WEST SUSSEX COUNTY COUNCIL CONSULTATION

TO:	Arun District Council FAO: Mr S Davis
FROM:	WSCC - Highways Authority
DATE:	6 July 2021
LOCATION:	Lidsey Lodge Farm Sack Lane Lidsey PO22 9PE
SUBJECT:	AL/75/21/PL Demolition of large agricultural buildings, removal of concrete yards and access, erection of 4 No.2 bed houses, 2 No. 3 bed houses, 2.No. 4 bed houses, gardens, access, parking, soft landscape and ecology areas. (resubmission following AL/27/21/PL). This application is a Departure from the Development Plan and is in CIL Zone 3 and is CIL Liable as new dwellings.
DATE OF SITE VISIT:	n/a
RECOMMENDATION:	No Objection
S106 CONTRIBUTION TOTAL:	n/a

BLOCK / SITE LAYOUT PLAN

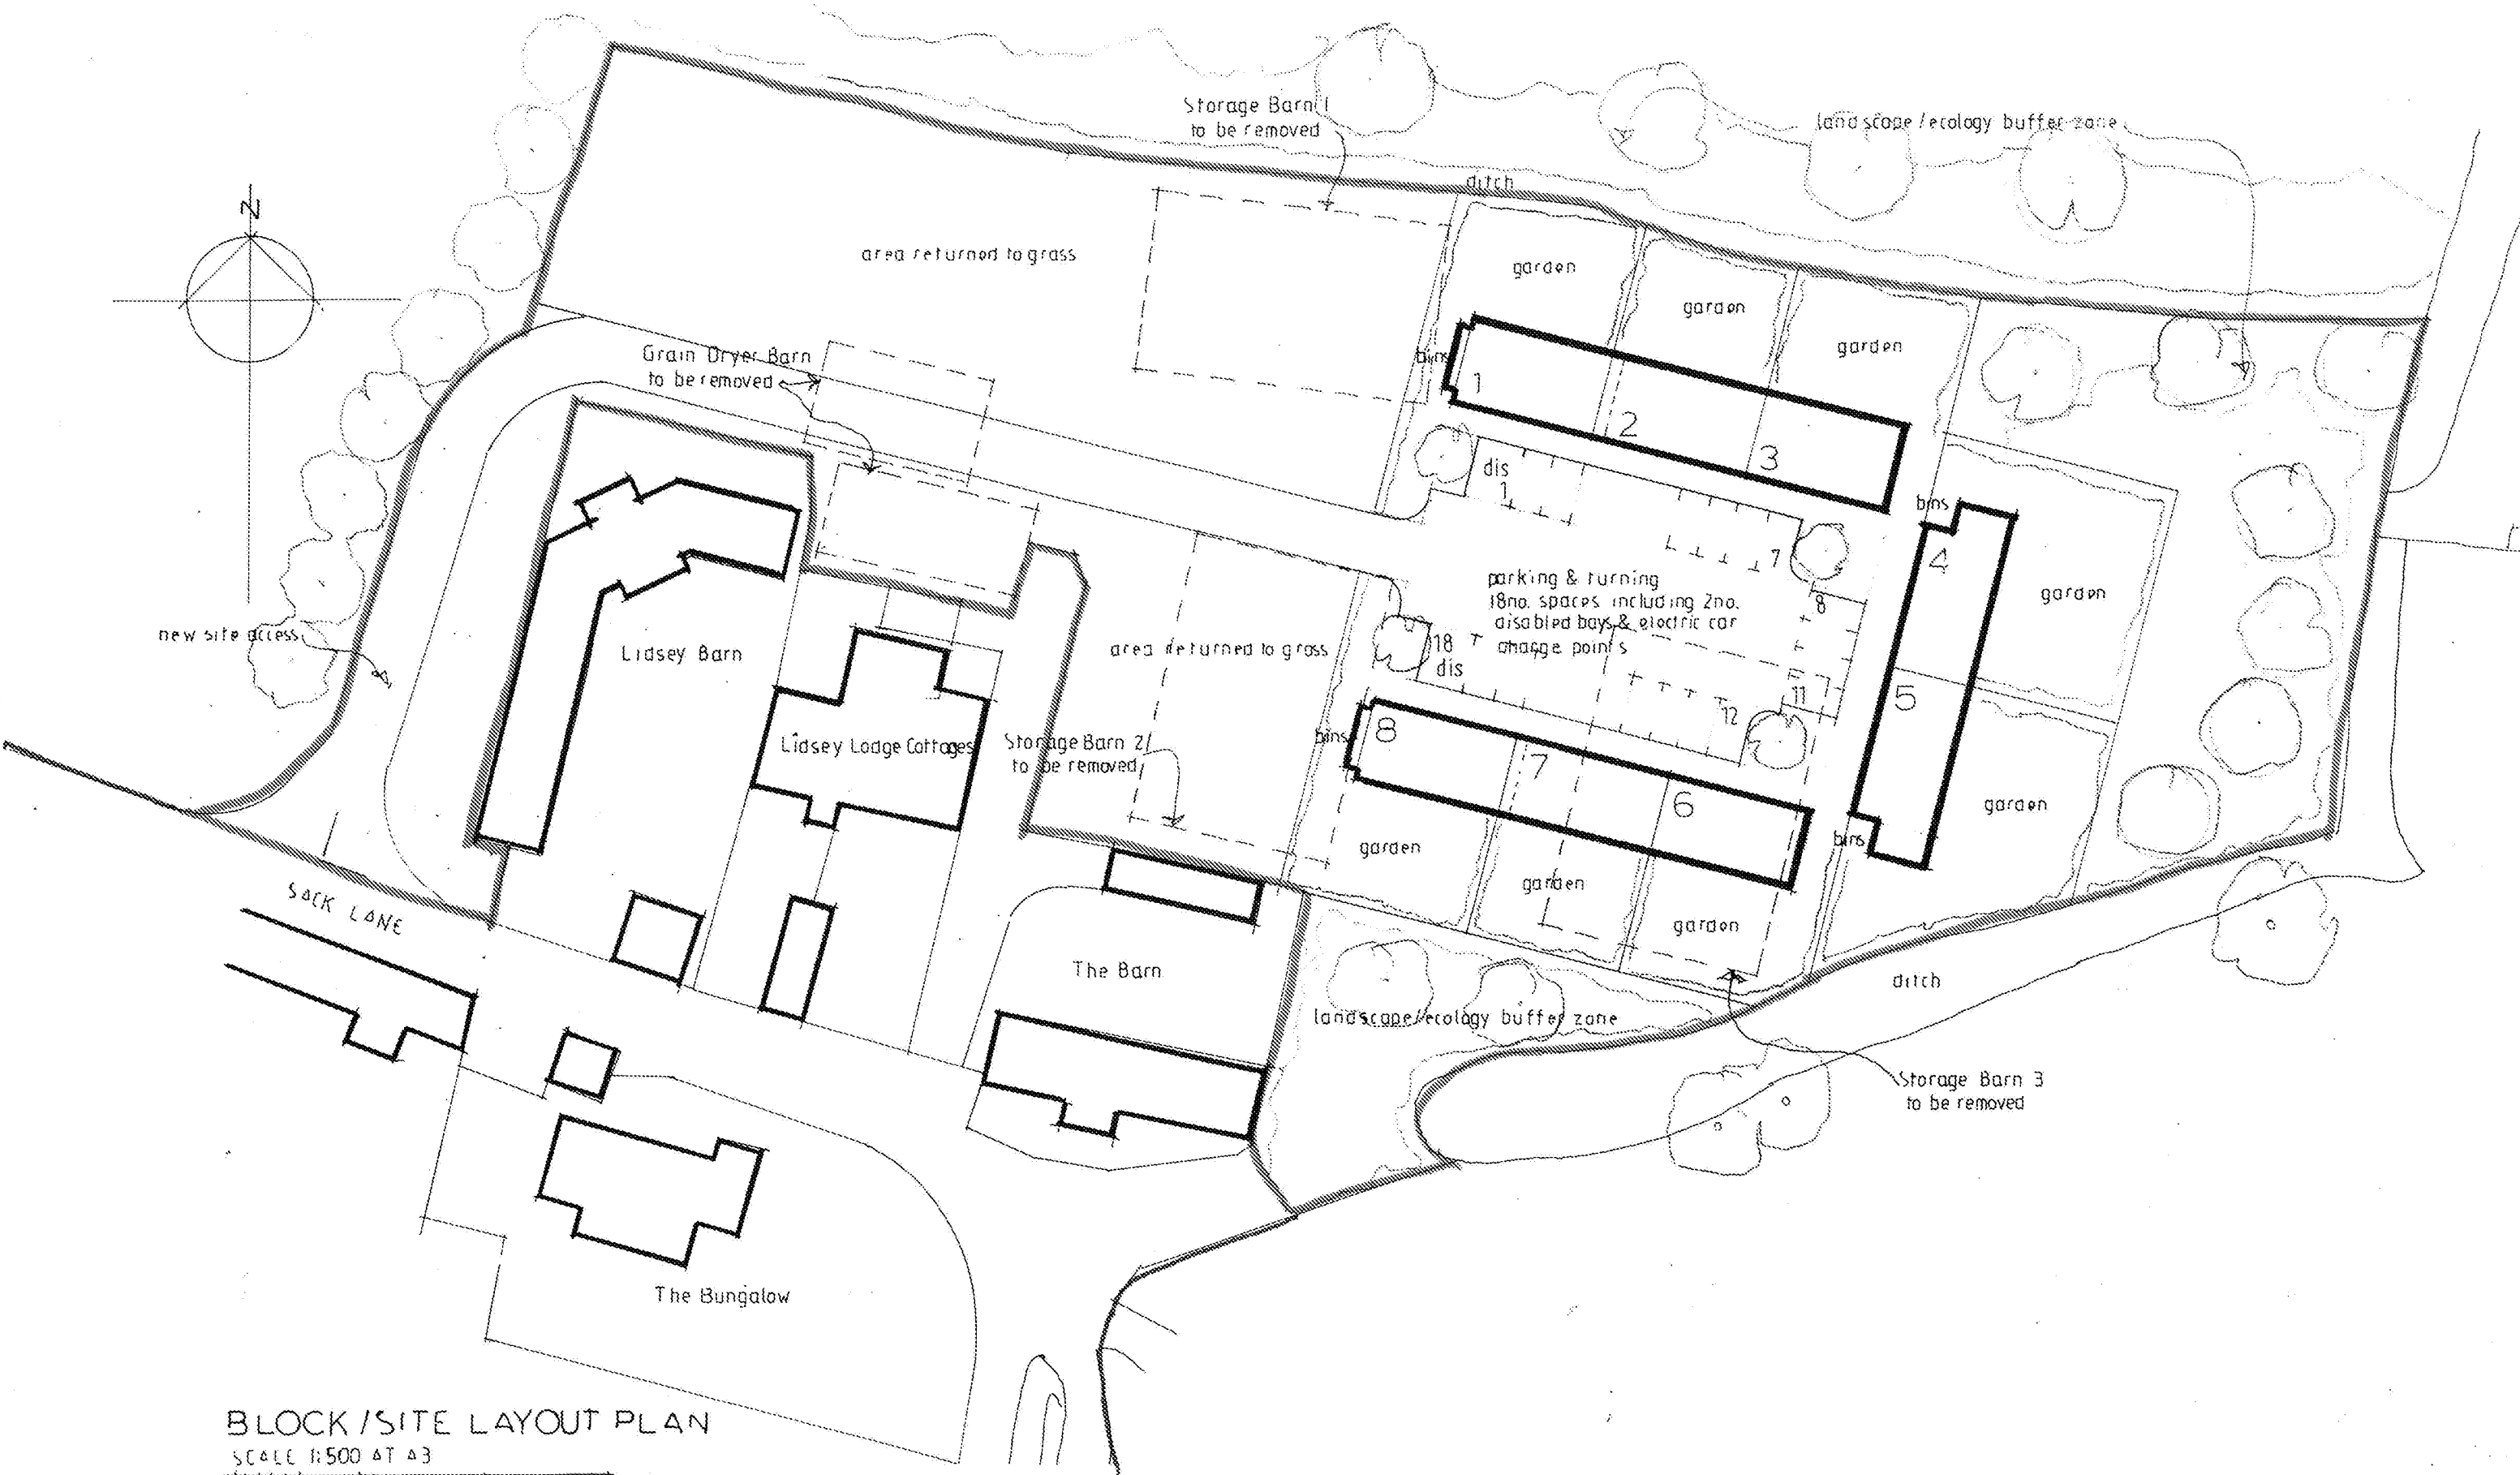
The Block/Site Layout plan shows a new access onto Sack Lane very close to the alignment of the existing access. It appears to be private property, however can the applicant confirm this in relation to the Highway Boundary to determine if a Minor Works Licence is required. If it is to join public highway, further details of the access design will be required.

- Confirmation of access design/proximity to public highway
- Confirmation cycle parking will be secure

May be required if the proposed access joins the public highway.

No part of the development shall be first occupied until such time as the vehicular access serving the development has been constructed in accordance with the details shown on the drawing titled XXX and numbered XXX.
